Application Reference: 2025/1093

Site Address: 12 Wentworth Crescent, Staincross, Barnsley, S75 6DR

Introduction: This application seeks full planning permission for a Single storey rear extension and new front porch to dwelling

Revisions	A.	21-01-26
This drawing is for planning permission only and is not a construction drawing.		
Drawing Title	EXISTING_REAR_SIDE_ELEVATIONS	
Job No. - Dwg No.	LDS/2025/13	-
Client:	Linda and Dean Strudwick 12 Wentworth Crescent Mapplewell, Barnsley S75 6DR	
Scale:	1:50

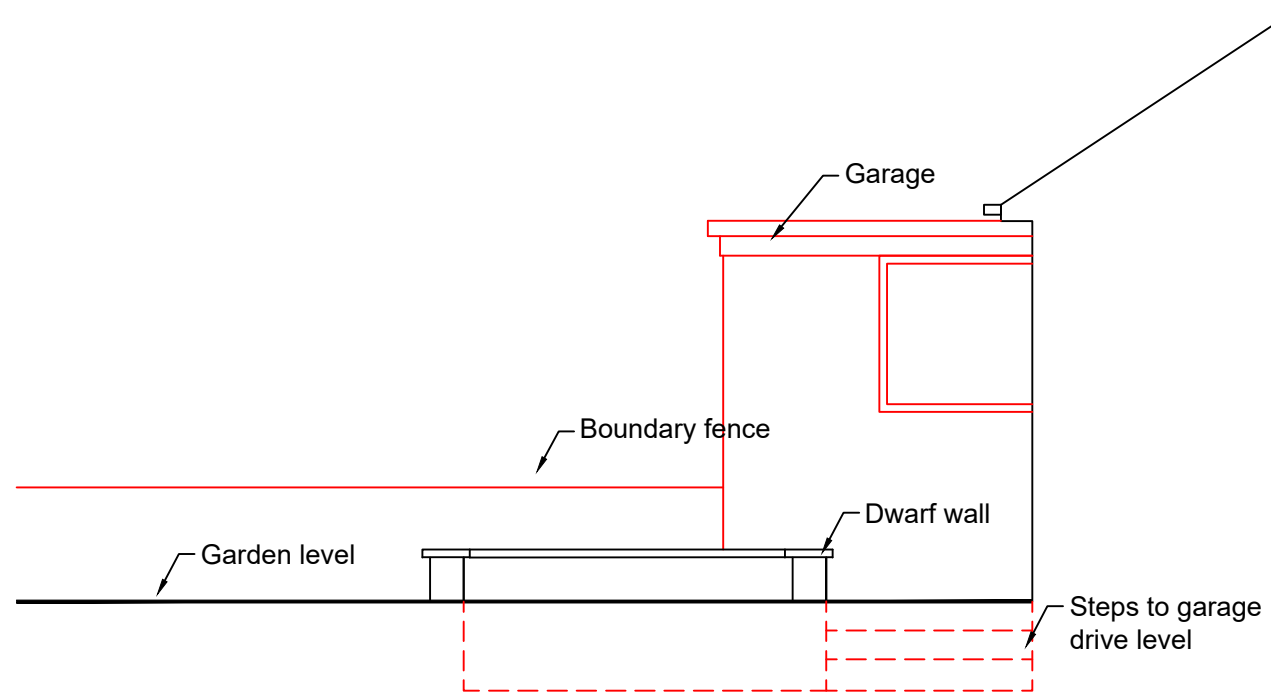
The proposed extension has a rear projection of the extension of approximately 6.075m. The eaves and ridge heights from ground level are approximately 2.53m and 3.94m respectively, and the extension is set within 2m of a side boundary treatment. In terms of compliance with the SPD, the eaves height of the extension exceeds the SPD guidance by 0.03m or 3cm which is not felt to be significant, however, the 2.075m excess in SPD recommended projection will need to be carefully assessed.

The application dwelling, at the current patio level is set approximately 0.75m below the ground level of the neighbouring dwelling. The opaque wooden boundary fence between the dwellings, installed in the neighbouring garden is approximately 1.55m high, but in the applicant's garden is effective at a height of 2.3m, sitting approximately 0.41m below the eaves height of the application dwelling, and 1.42m below the eave height of the neighbouring dwelling. With the eaves height of the extension matching the eaves height of the original dwelling, the bulk of the extension would be at a height of approximately 1.79m, or only 24cm above the height of the existing boundary fence. In addition to the mitigation of the fence, the peak ridge height would be the equivalent of approximately 3.22m instead of the true height 3.94m, when viewed from the neighbouring garden.

In terms of the 45-degree rule and overbearing impact to windows, the angle from the centre of the neighbouring dwelling's ground floor bedroom window has been measured and the extension does not meet this, however additional mitigation arises through the level difference of the dwellings, despite them being a pair of semi-detached bungalows. Furthermore, the peak ridge height is located approximately 3.75m from the midpoint of the neighbour's bedroom window, which should reduce any overbearing impact to this window.

In terms of overlooking impact, there are a set of French style doors and slim windows on the side elevation of the proposed extension, and the feature window on the rear elevation of the extension. All these windows and doors are at ground floor level and overlook into the applicant's garden. There are no windows or doors overlooking the attached neighbouring dwelling, and there is an approximate distance of 8.9m between the extension and the boundary treatment with the unattached neighbour to the west.
